# **Consultee Comments for Planning Application 23/03282/PLF**

Application Number: 23/03282/PLF

Proposal: Erection of 4 timber seating huts following demolition of existing huts

Name: . Yorkshire Water Services Ltd Developer Services

Title:
Proposed External Seating Hut.

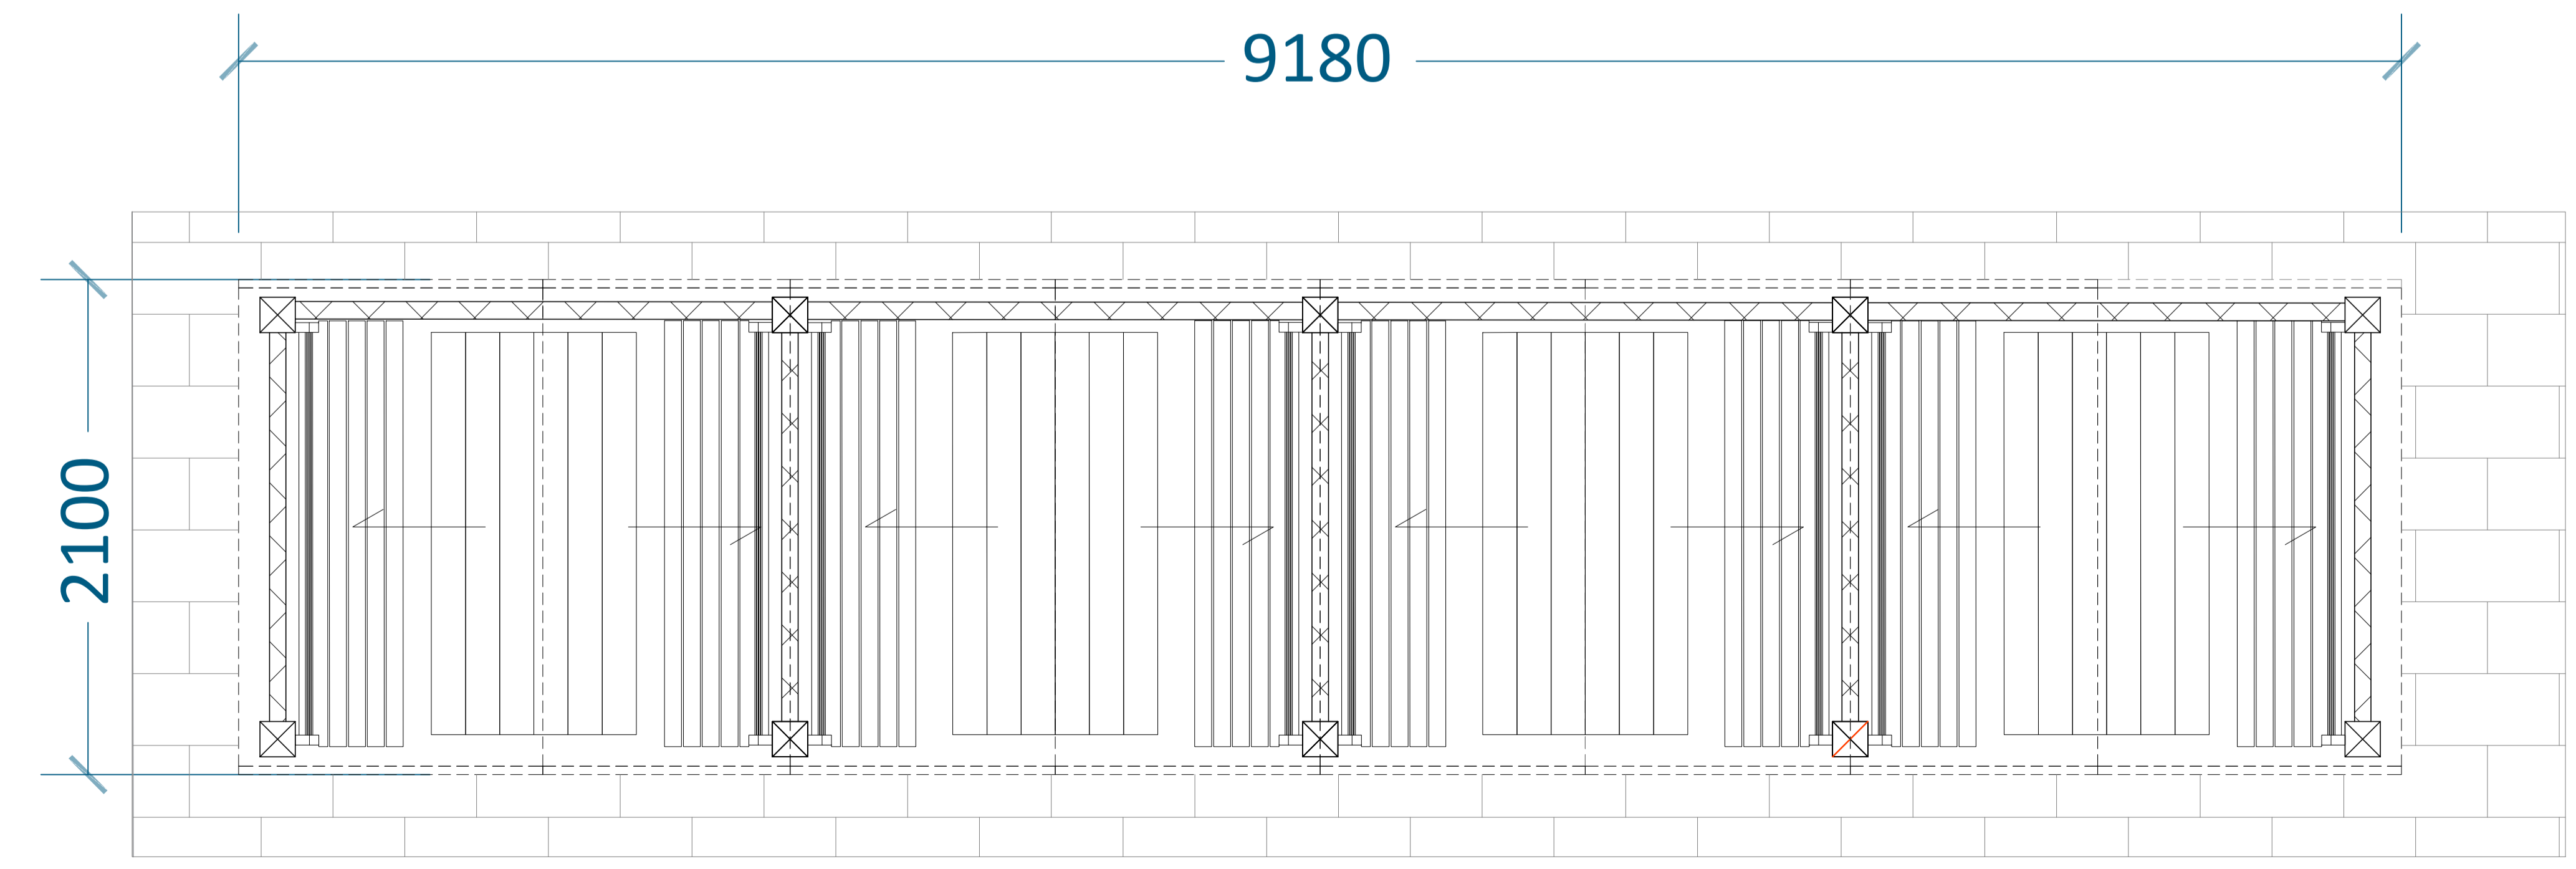
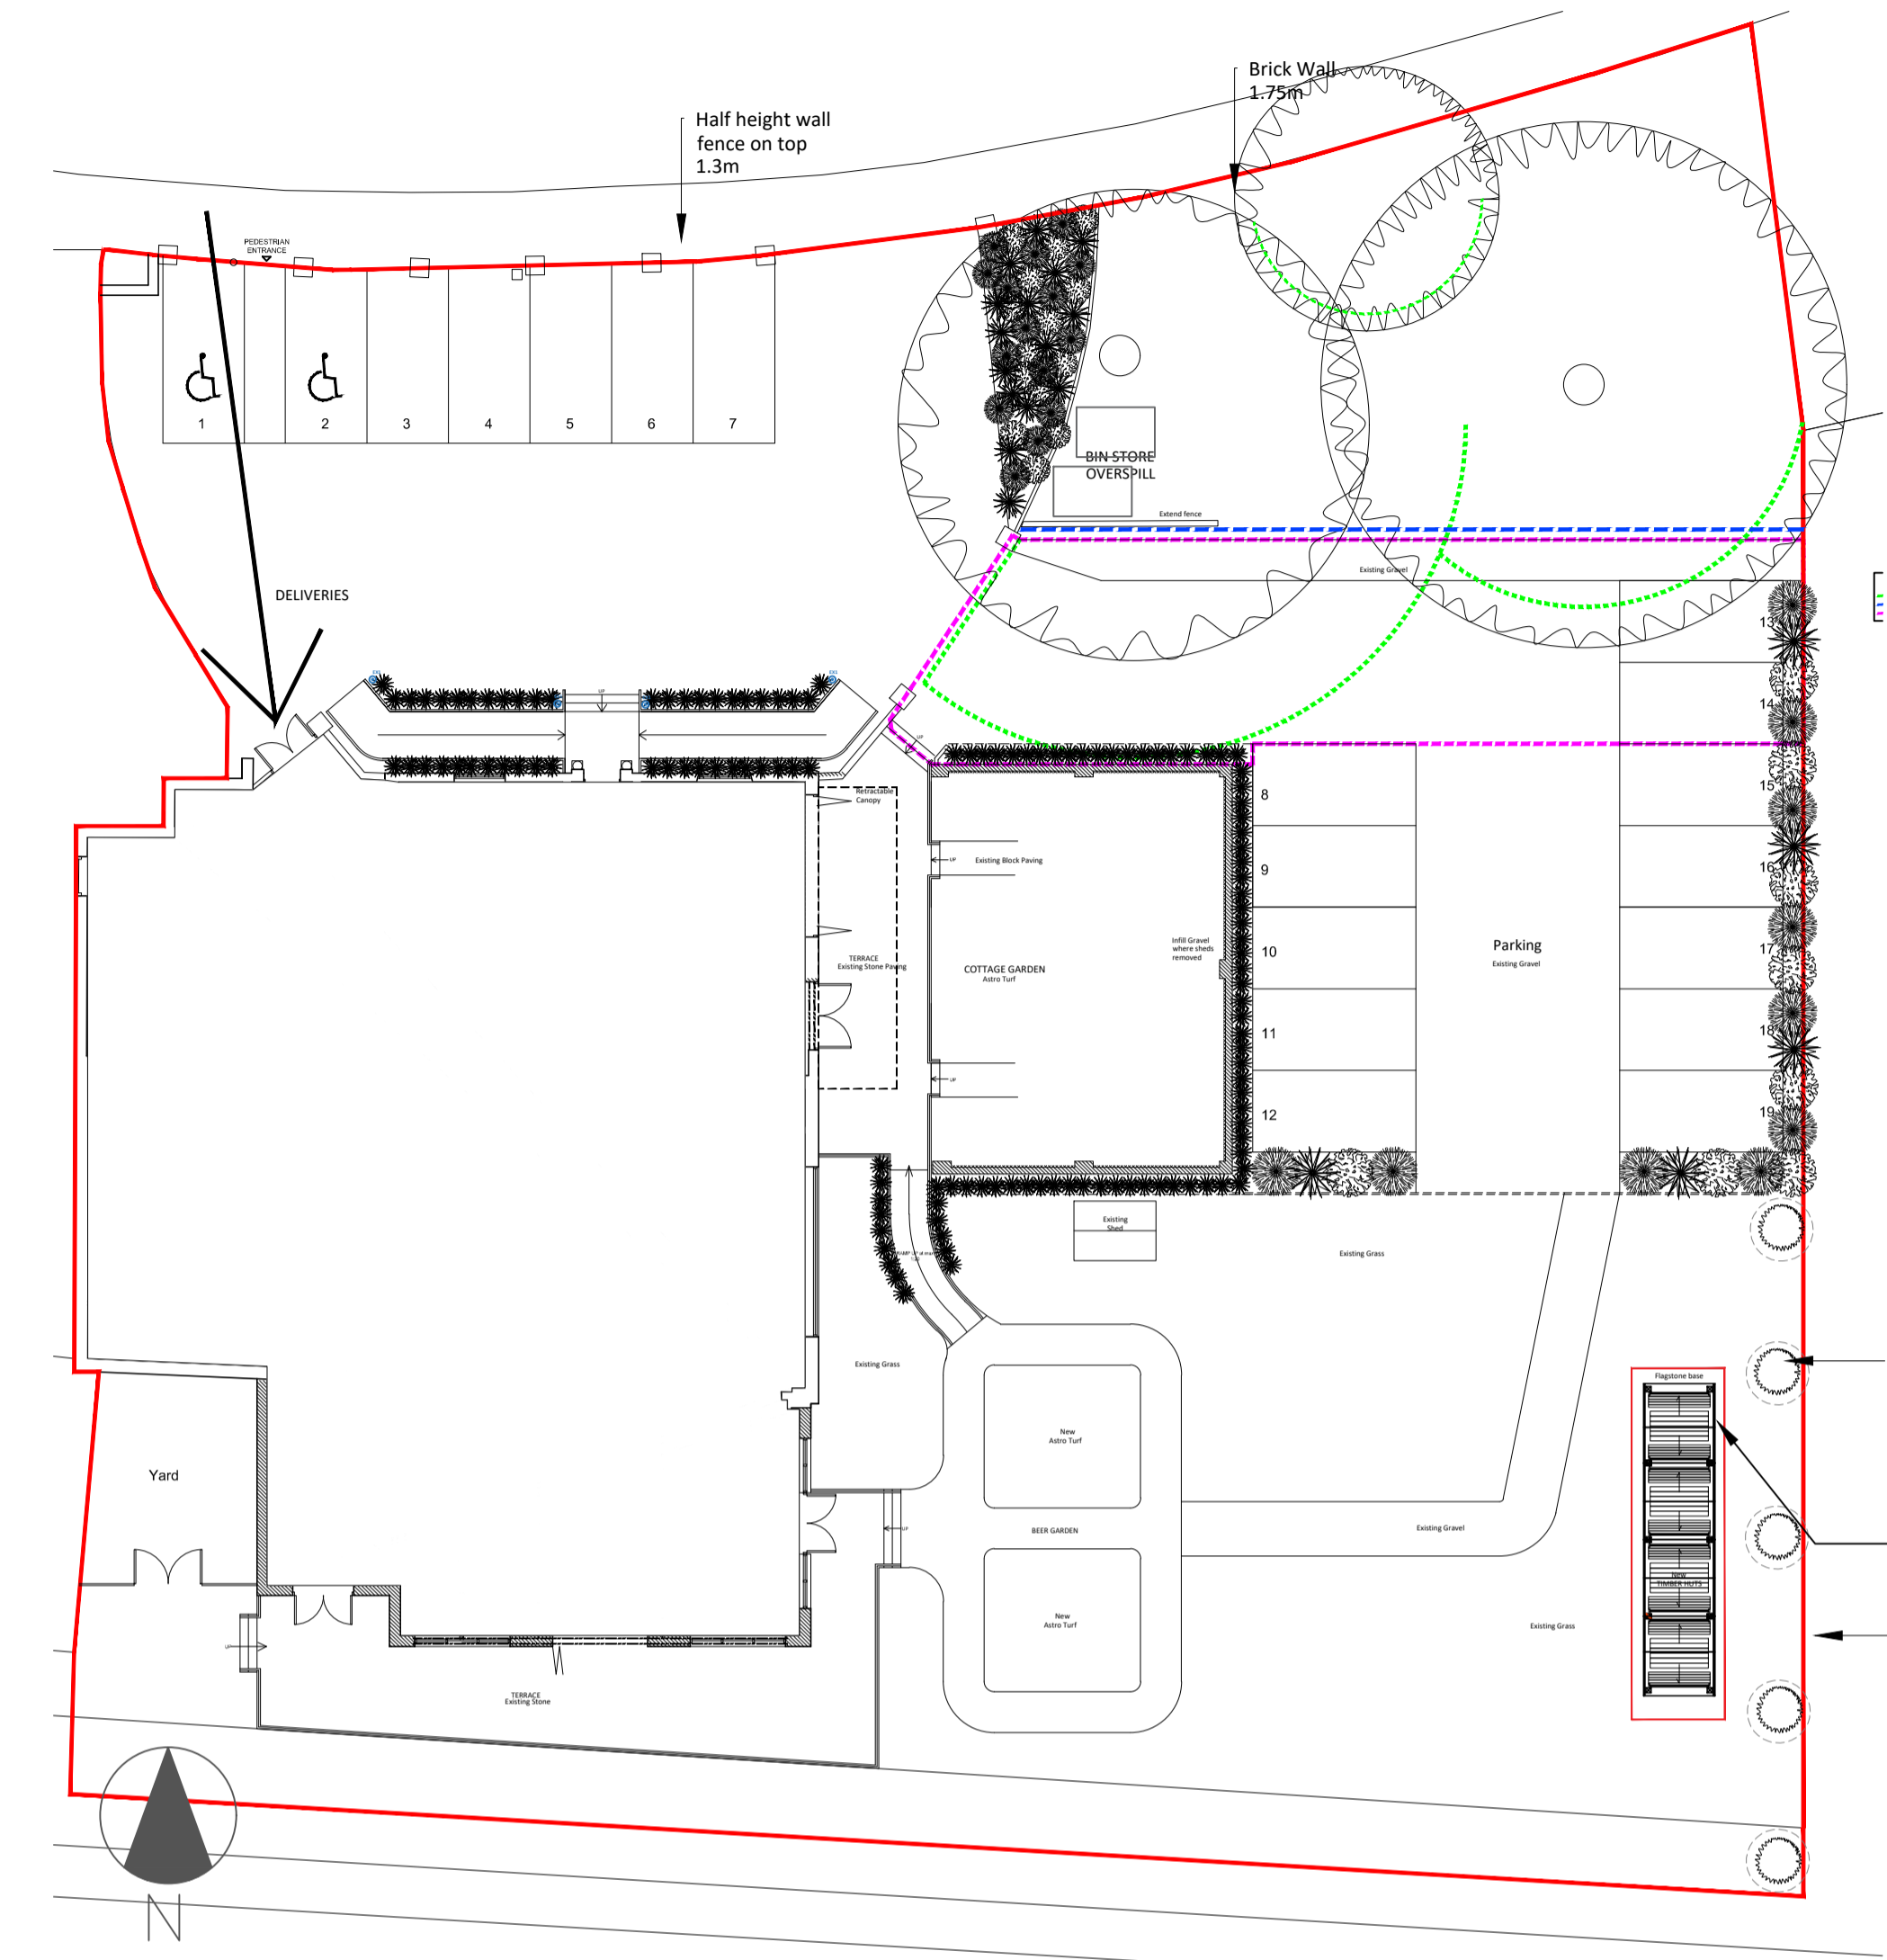
Details reviewed - Noted foul water ticked as to Main Sewer though not applicable and same with regards to surface water also ticked to Main Sewer - any surface water from the roofs of the huts should naturally soak into the existing green space area as shown on the proposed site layout and nothing showing as to foul water from the huts position.
